Royal Prince Alfred Hospital North West Precinct Redevelopment

SECTION 75W APPLICATION

Architectural Design Statement

Document Reference: 3599-0603-012

DEPARTMENT OF PLANNING SUBMISSION
LEVEL 3 PLAN - MENTAL HEALTH INPATIENT UNIT -
25 BED ACUTE
ROYAL PRINCE ALFRED HOSPITAL
North West Precinct Project, Camperdown

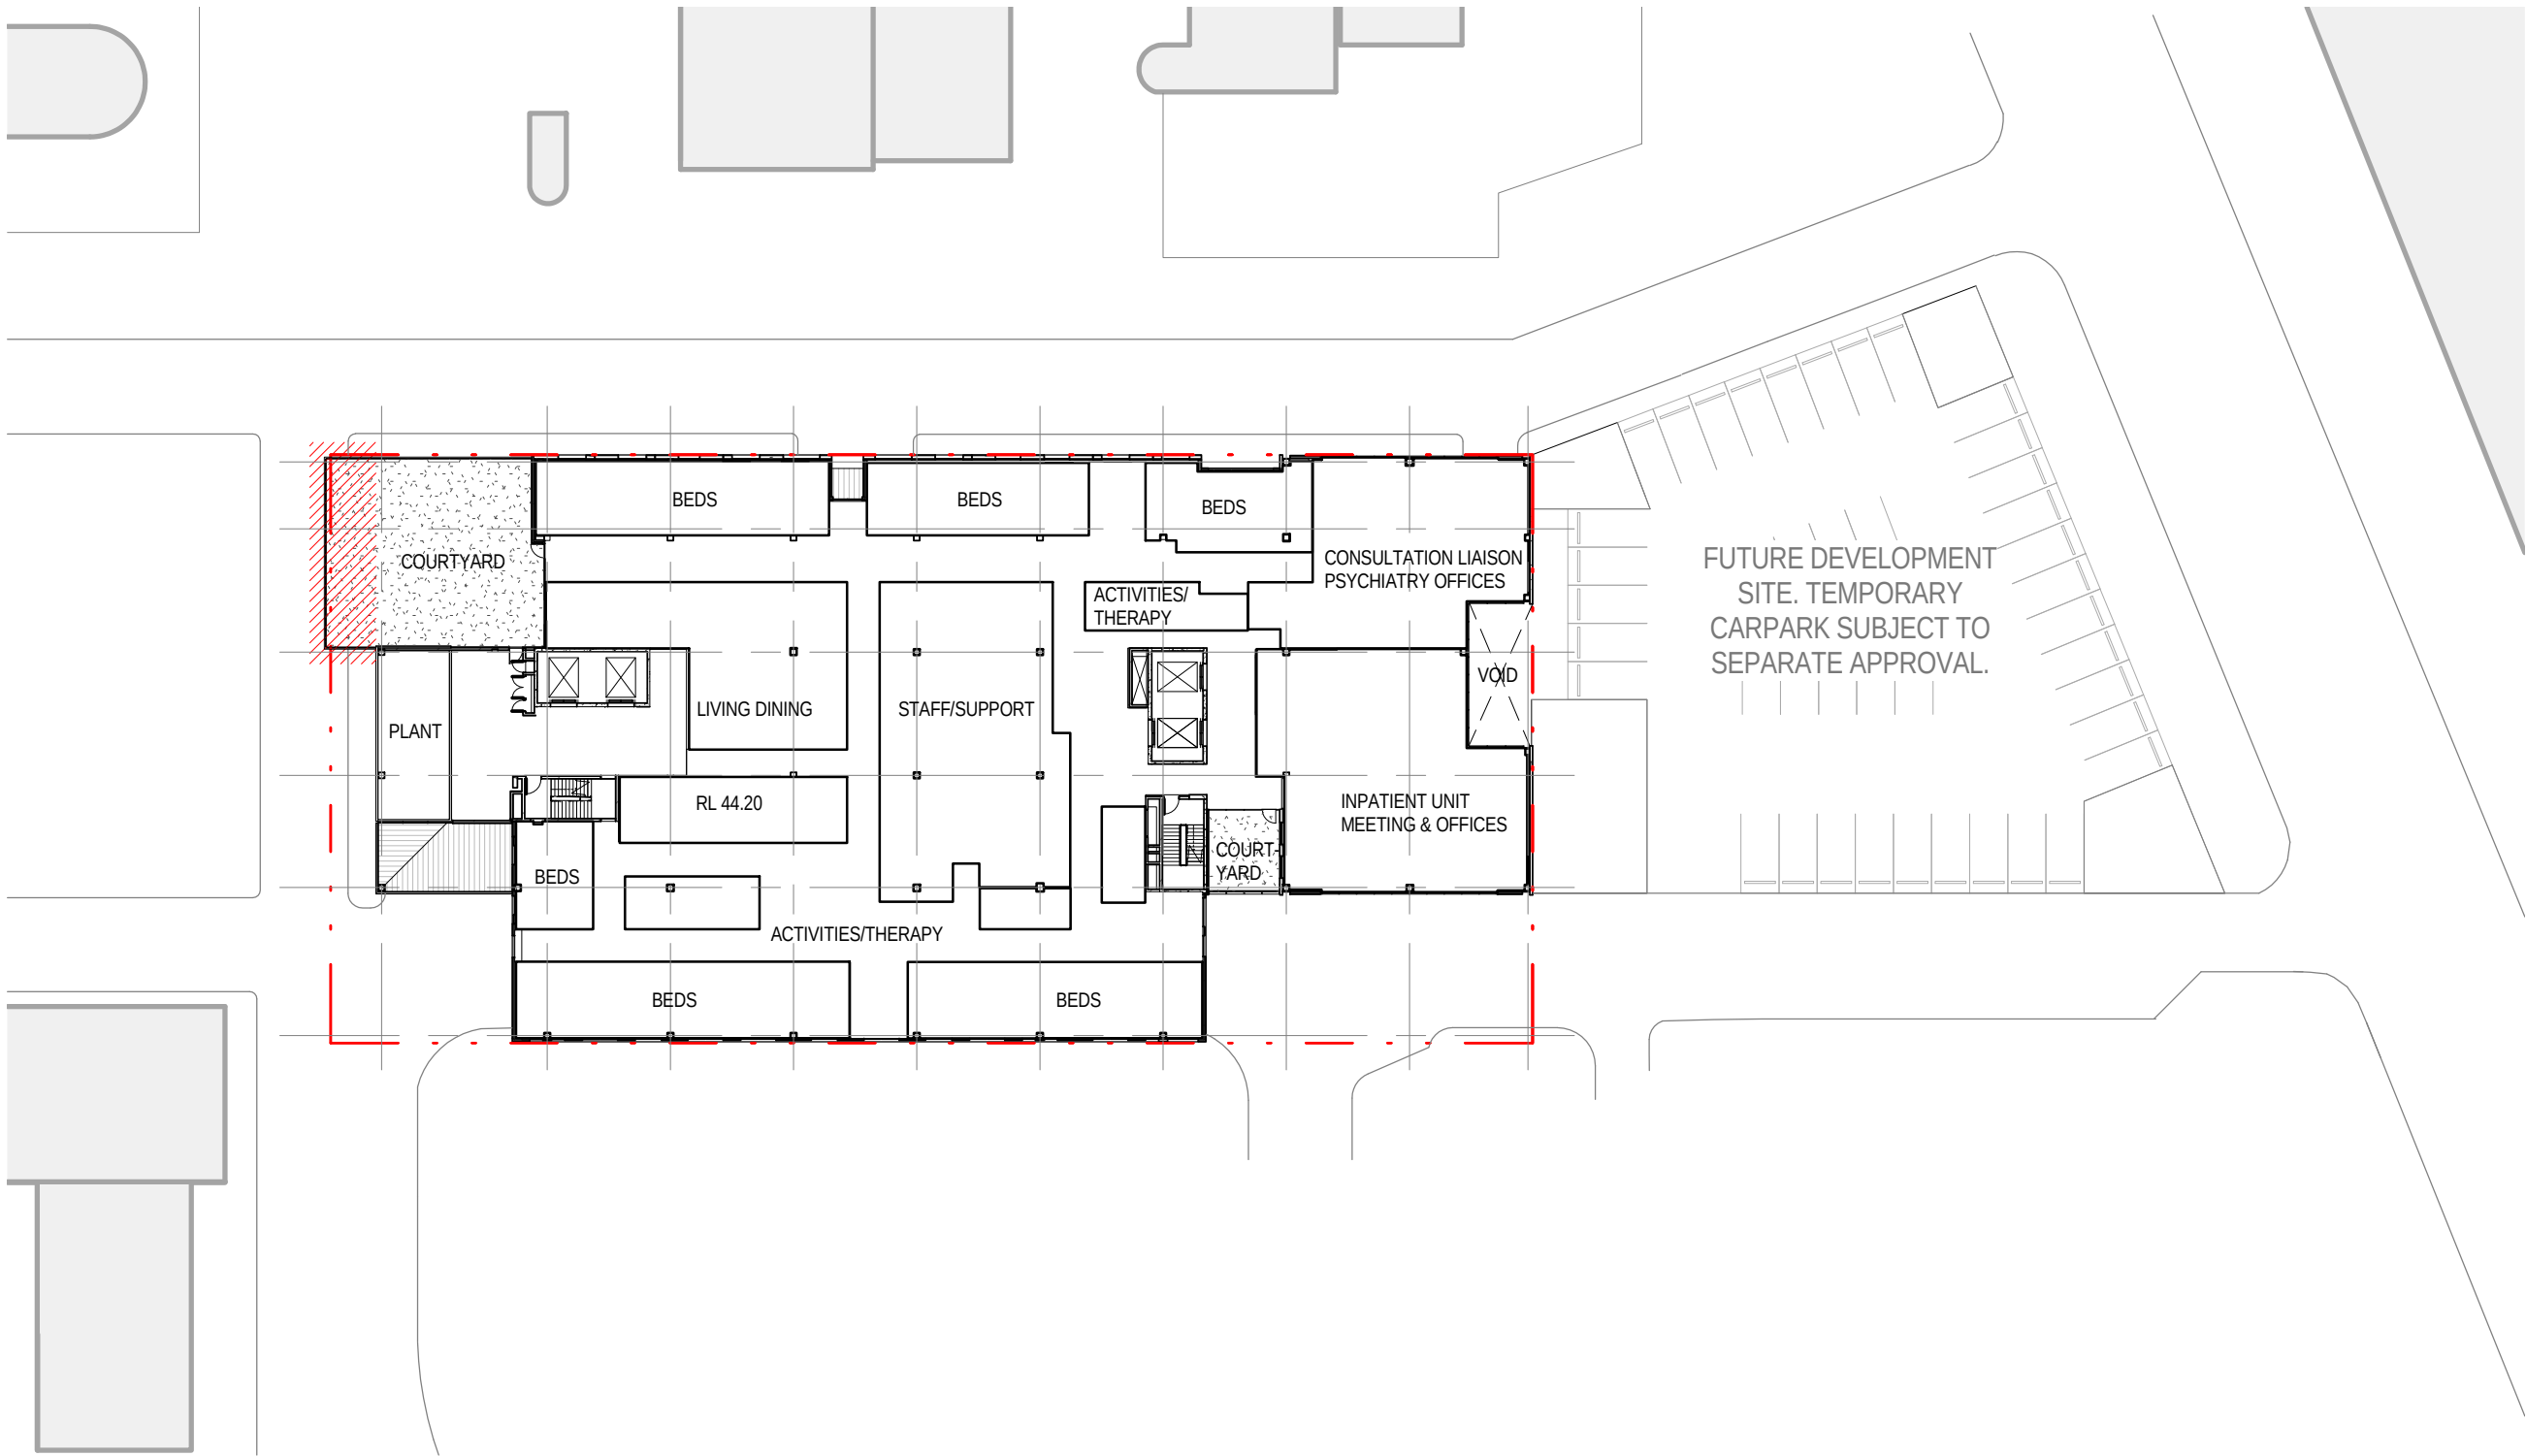
2.1 Level 3 Acute Mental Health Inpatient Unit courtyard; and Level 4 Female High Dependency Unit courtyard

- The Level 3 Acute Mental Health Inpatient Unit courtyard is extended west by 3.4metres, cantilevering over New Hospital Road; and
- The Level 4 Female High Dependency Unit courtyard is reconfigured, and extended west over New Hospital Road by 1.4metres and partially to the south to align with the building footprint extent.

DEPARTMENT OF PLANNING SUBMISSION
ELEVATION - SHEET 3
ROYAL PRINCE ALFRED HOSPITAL
North West Precinct Project, Camperdown

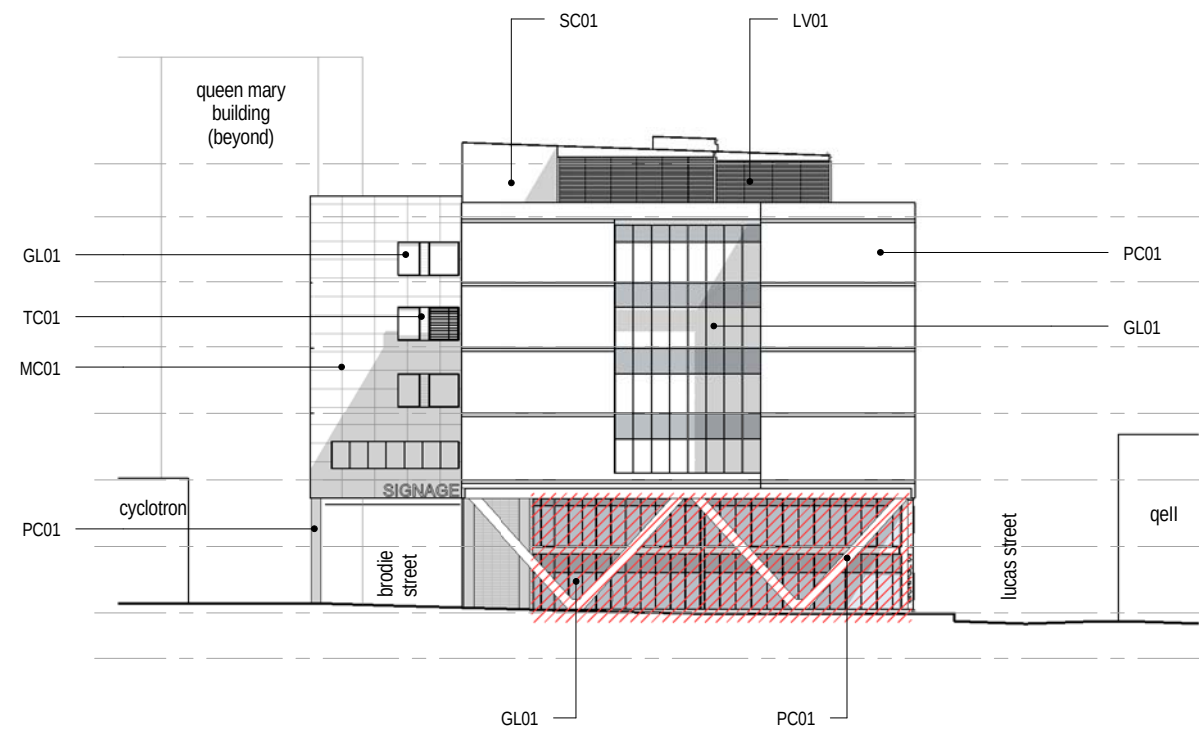
Updated elevations are provided as part of the architectural drawings to incorporate the cantilevers as outlined above. Architecturally, the cantilevered levels provides some variation to the visual bulk of the west portion of the building, ensuring some

Drawing	Title	Revision	Comment/updated item
DoP-050	Site Plan	3	Courtyard extensions to Levels 3 and 4.
DoP-100	Ground Level Plan	3	Ground level entry and vehicle drop off revised. DDA ramp removed, platform lift shown. Entry to the Mental Health Assessment Unit and Short Stay Units has been revised to eliminate the ramp on Brodie Street.
DoP-101	Level 1 Plan	3	Façade line altered in line with ground level changes.
DoP-103	Level 3 Plan	3	Increase to Level 3 courtyard.
DoP-104	Level 4 Plan	3	Increase to Level 4 Female HDU courtyard.
DoP-200	Elevation – Sheet 1	3	Minor changes to ground and level 1 glazing at entry and vehicle drop-off. Courtyard cantilever to Level 3.
DoP-201	Elevation – Sheet 2	3	Courtyard cantilever to Level 4. Revised MHAU and Short Stay unit entrance. Building configuration and extent within the entry and vehicle drop-off.
DoP-202	Elevation – Sheet 3	3	Increased extent of terracade cladding on the western façade to conceal mechanical ductwork.
